Appeal Decision

Appeal Ref: APP/T2350/W/24/3350099

Scott House, Green Moor Lane, Ribchester PR3 2YR

- The appeal is made under section 78 of the Town and Country Planning Act 1990 (as amended) against a refusal to grant planning permission.
 - The appeal is made by Laura Proos against the decision of Ribble Valley Borough Council.
 - The application Ref is 3/2023/0720.
 - The development proposed is described as 'stable block.'
-

Project Scott House, Green Moor Lane, Preston PR3 2YR			
Title Proposed new Stable Block			
Scale @ A1 1:50/100	Date July 2023	Ref 198	Drawn JSWR
Drg No 198/SHG/PL1			Rev C

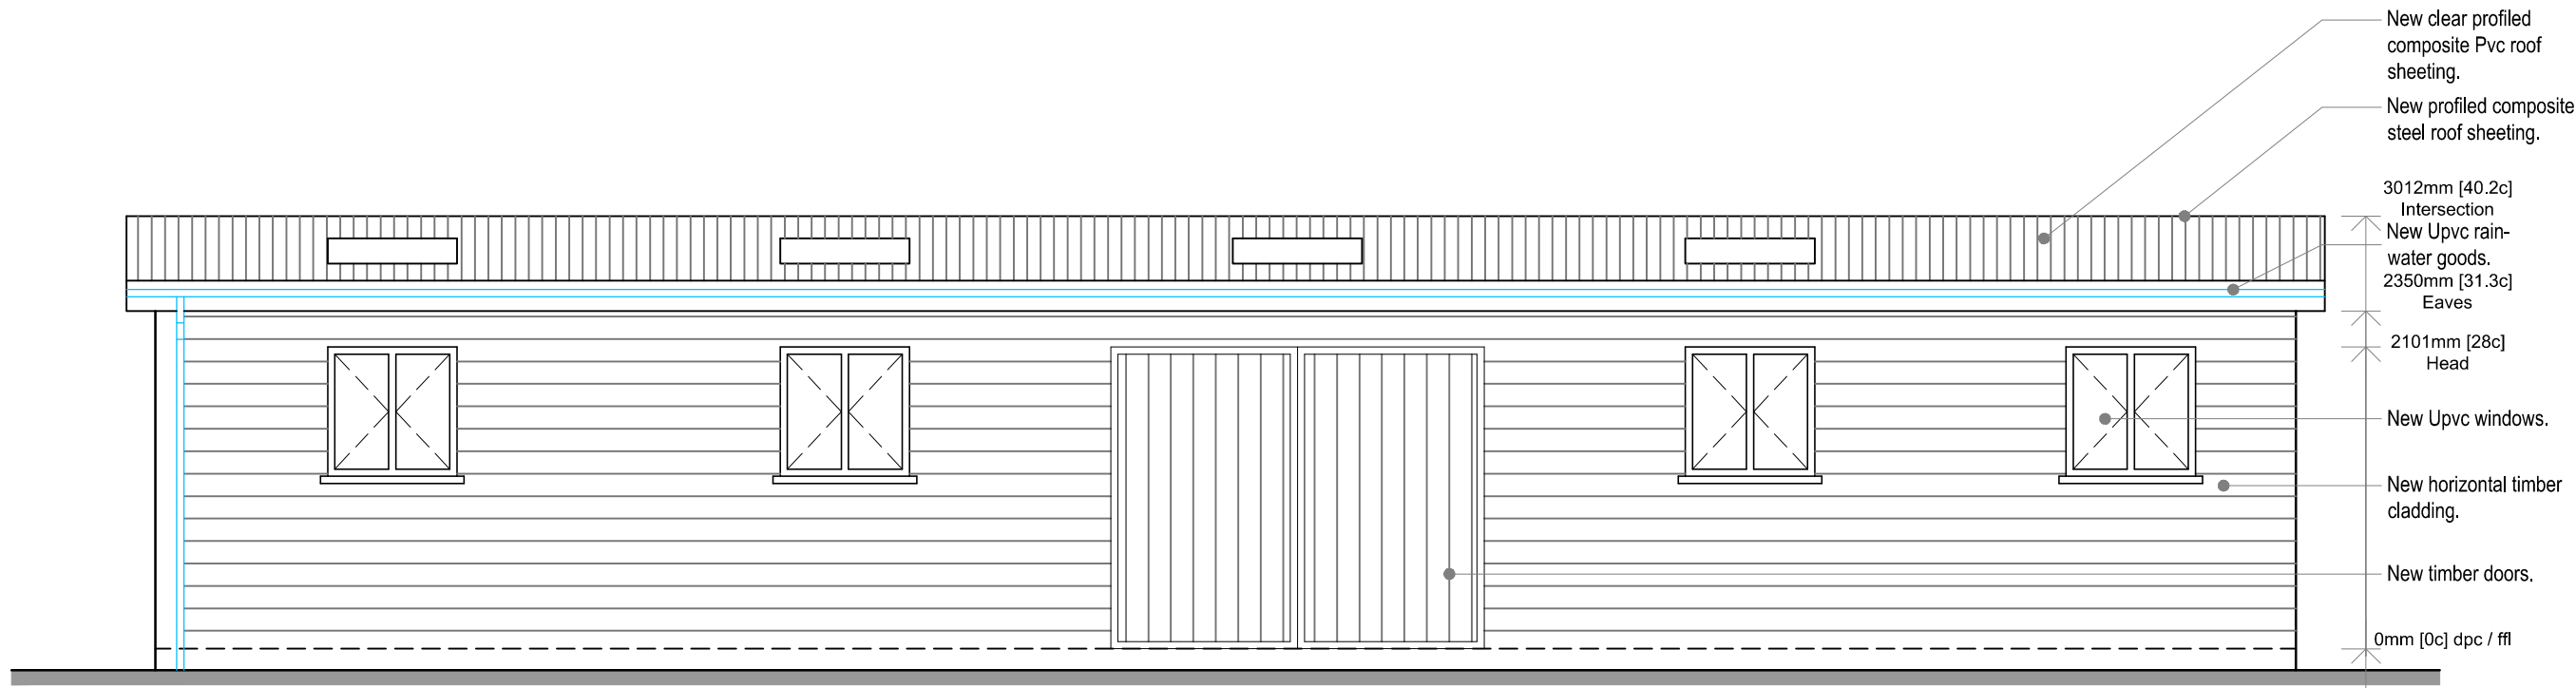
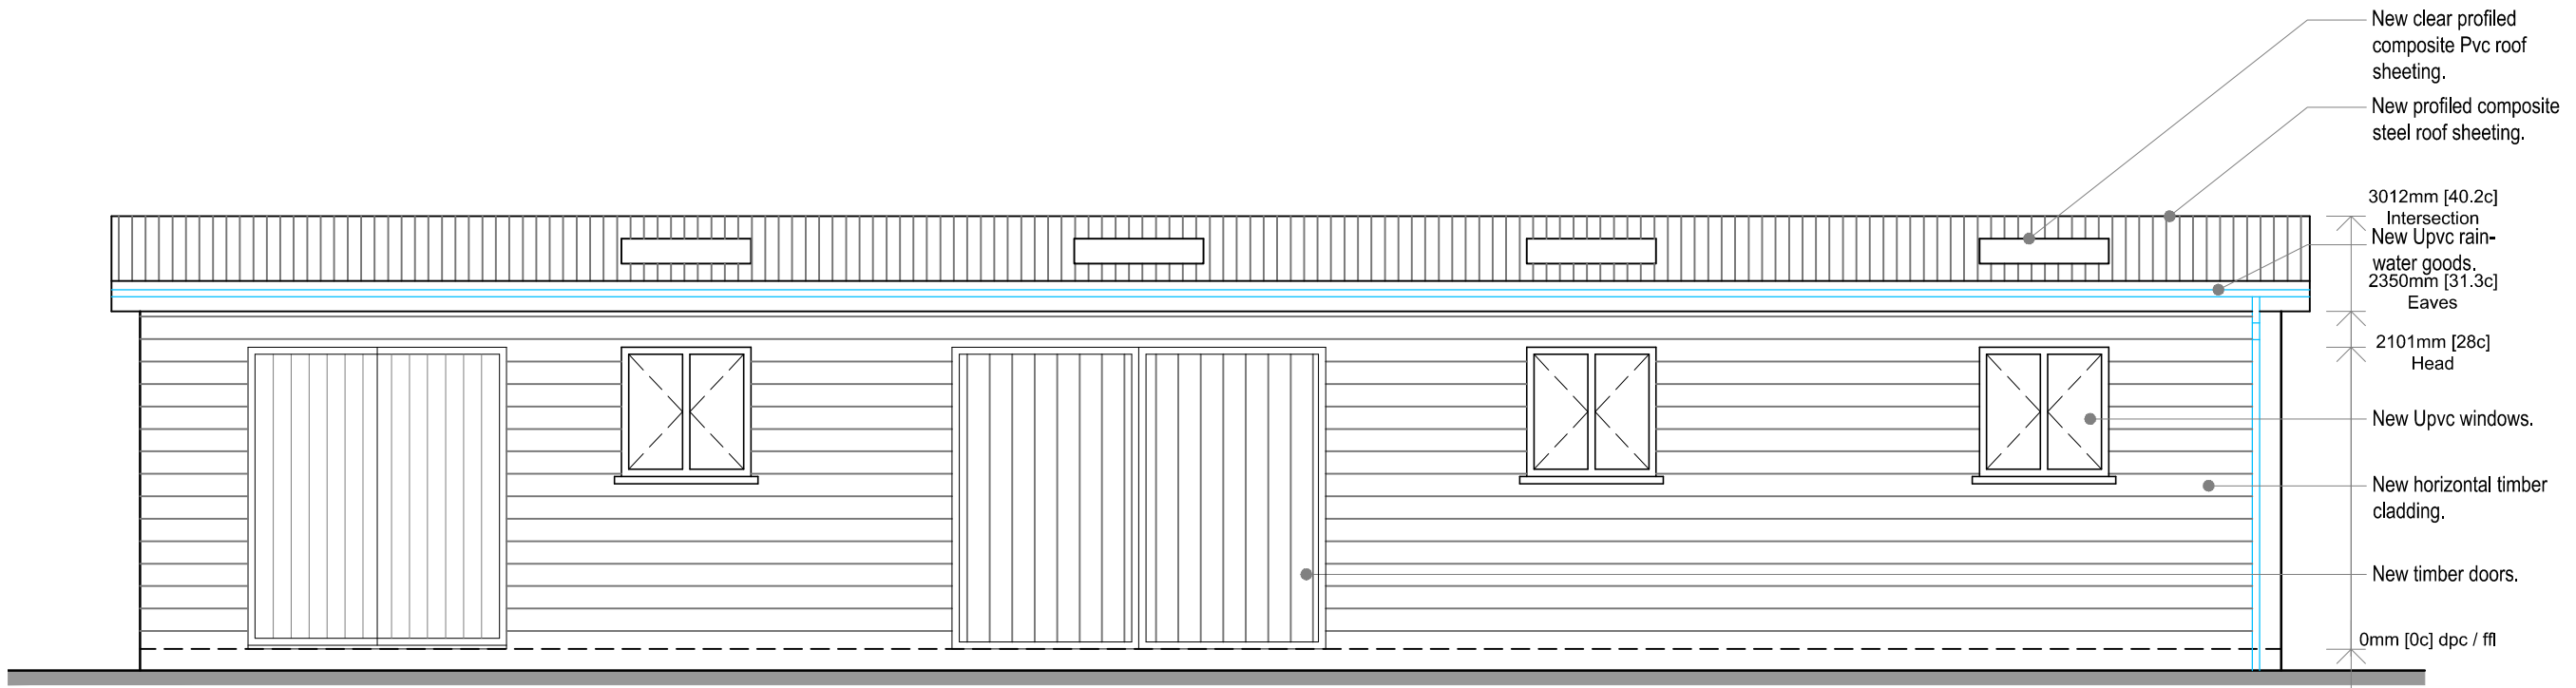
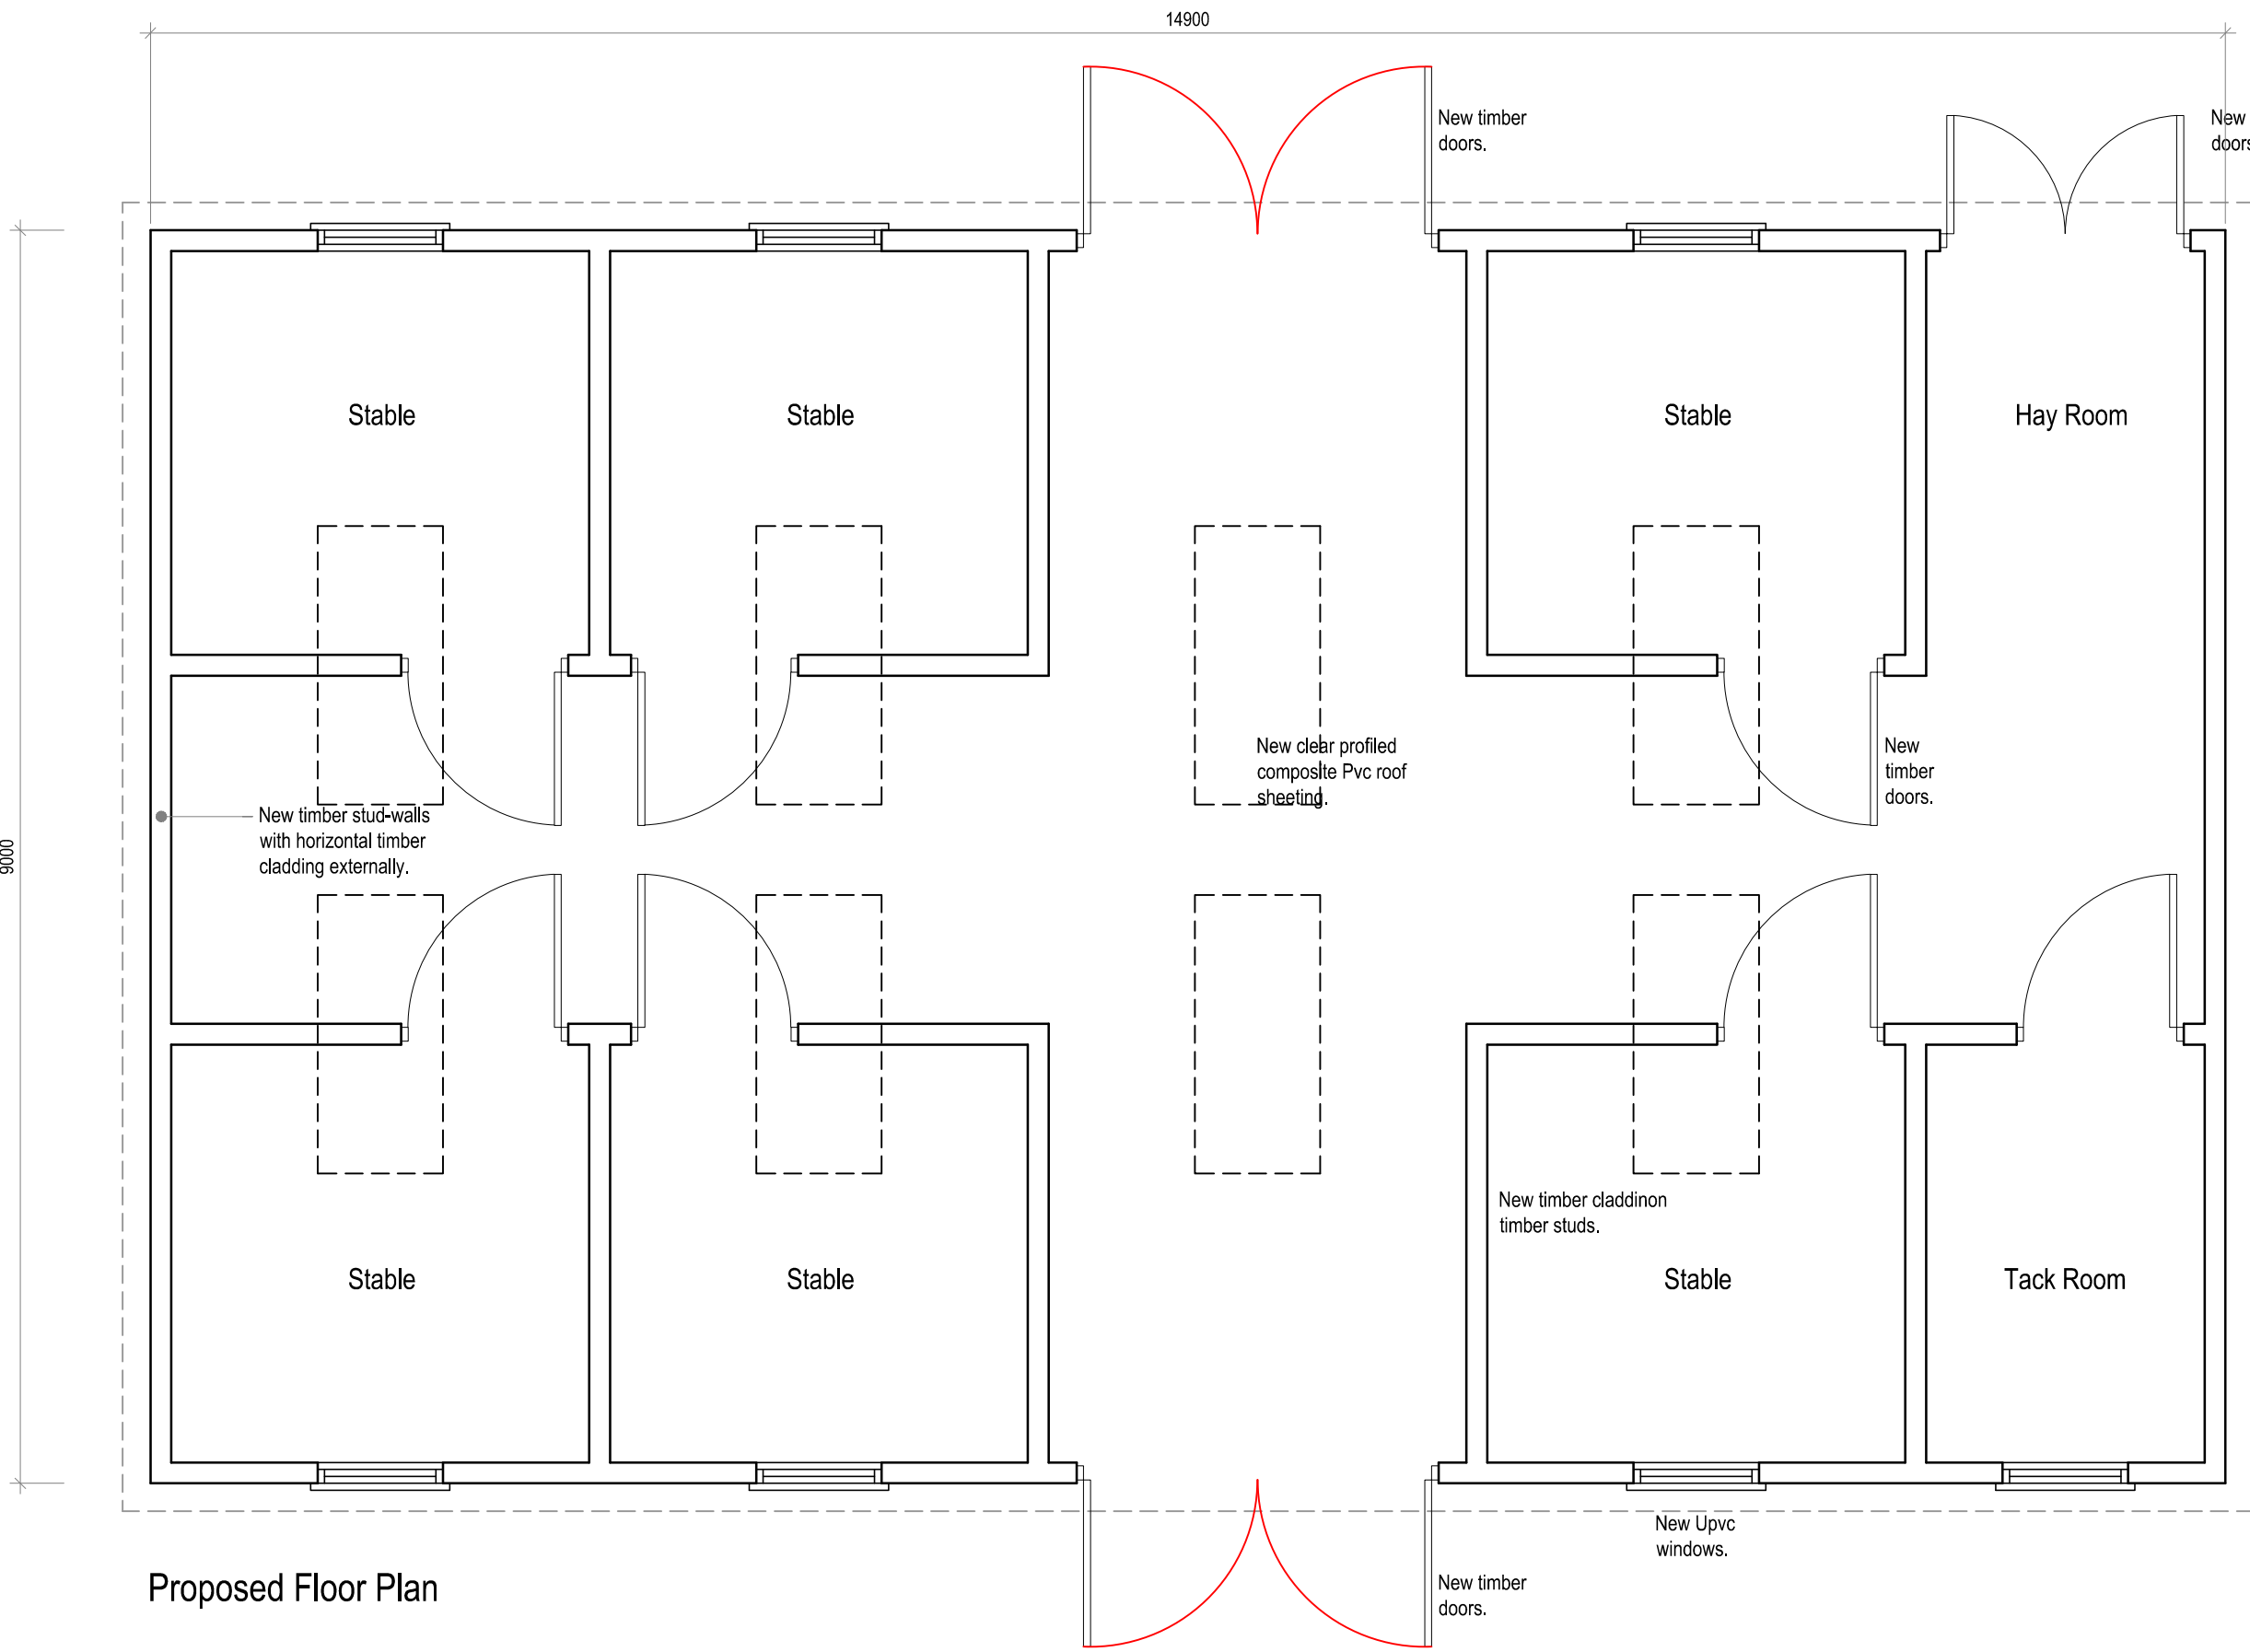
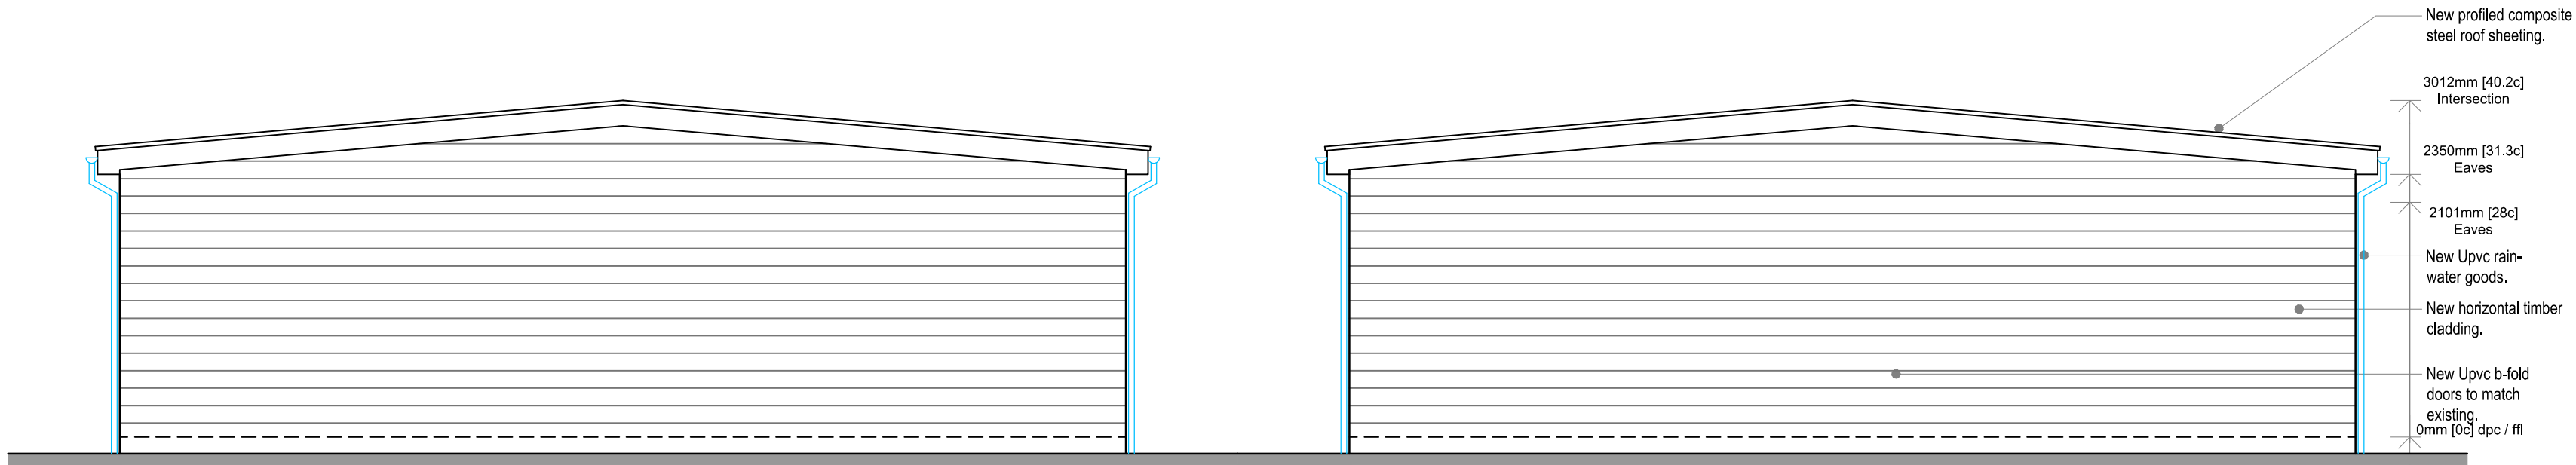
9. Nevertheless, I must assess the proposed building. This would be more than double the footprint of the existing building and not dissimilar to the footprint of the dwellinghouse. However, there is no specific size restriction within Policy DM2, other than the requirement for the development to be considered small-scale. I note that no evidence has been presented to indicate that the proposed stables are the minimum size necessary for the type and size of horses kept, or that the amount of internal circulation or storage space is reasonably required, relative to the specific equine needs. The ambiguity in the evidence presented does not give me confidence that the proposal could be reasonably considered as small-scale in this instance.

11. It is not unusual to see stables within countryside locations and I do not doubt the importance of providing shelter for horses. However, the proposed building would not have a typical equine appearance. Numerous UPVC casement window openings would be a highly unusual feature of a stable block. They, along with the unusually shallow pitched roof would give the building a squat, unfamiliar appearance that would be neither equestrian nor domestic but a strange hybrid of the two. It would not therefore appear characteristic of the rural environment in which it would be located.
